From: Michael Eastham
Sent: 21 February 2019 16:39
To: Planning.Responses
Subject: FW: Sport England Response : WA/95/18/RES - Land east of Tye Lane, Walberton - Reserved Matters for 175 dwellings and associated works

From: Stuart Morgans [REDACTED]
Sent: 21 February 2019 14:46
To: Michael Eastham
Subject: RE: Sport England Response : WA/95/18/RES - Land east of Tye Lane, Walberton - Reserved Matters for 175 dwellings and associated works

Subject: Sport England Response : WA/95/18/RES - Land east of Tye Lane, Walberton - Reserved Matters for 175 dwellings and associated works

PLAY & RECREATION DIAGRAM

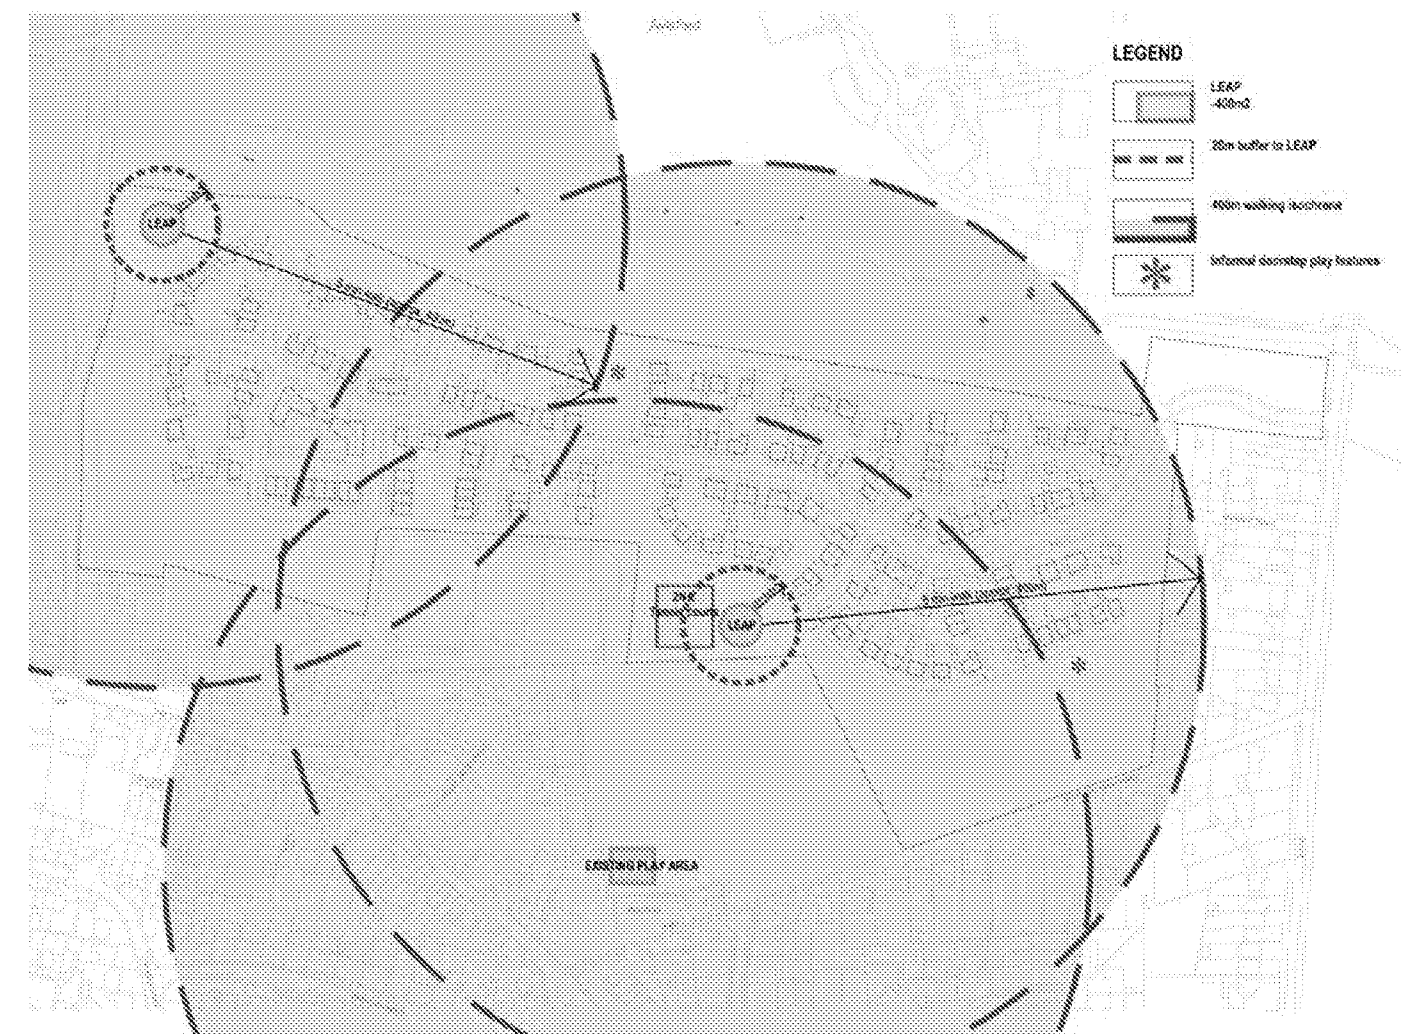
Sport England seeks to ensure the new sports facilities are fit for purpose. There is little detail in the proposed plans to confirm the design and specification of the courts. Whilst they are shown to be of an

appropriate size, no details are provided to confirm the proposed surface specification, or associated ball catch fencing details which should be provided. A cross section of the court surface through to the sub-base should also be provided to demonstrate that this accords with the relevant design guidance (see below link). There are no details to confirm whether or not the courts are to be floodlit, but if they are, further details of the floodlighting should also be proposed. Having reviewed the outline decision notice, there does not appear to be an existing planning condition under which these details could be provided, and so it is recommended that either further details are requested to be submitted to be determined as part of this reserved matters application, or the following condition be imposed on the reserved matters consent:

Prior to the commencement of the construction of the tennis courts shown on the approved plans, further details of the design and specification of the tennis courts playing surface and sub-construction, associated ball catch fencing, and any floodlighting (where floodlighting is to be provided) have been submitted to and approved in writing by the Local Planning Authority in consultation with Sport England. The tennis courts shall not be constructed other than in accordance with the approved details and shall be made available for use prior to the first occupation of plots 36-40 (inc).
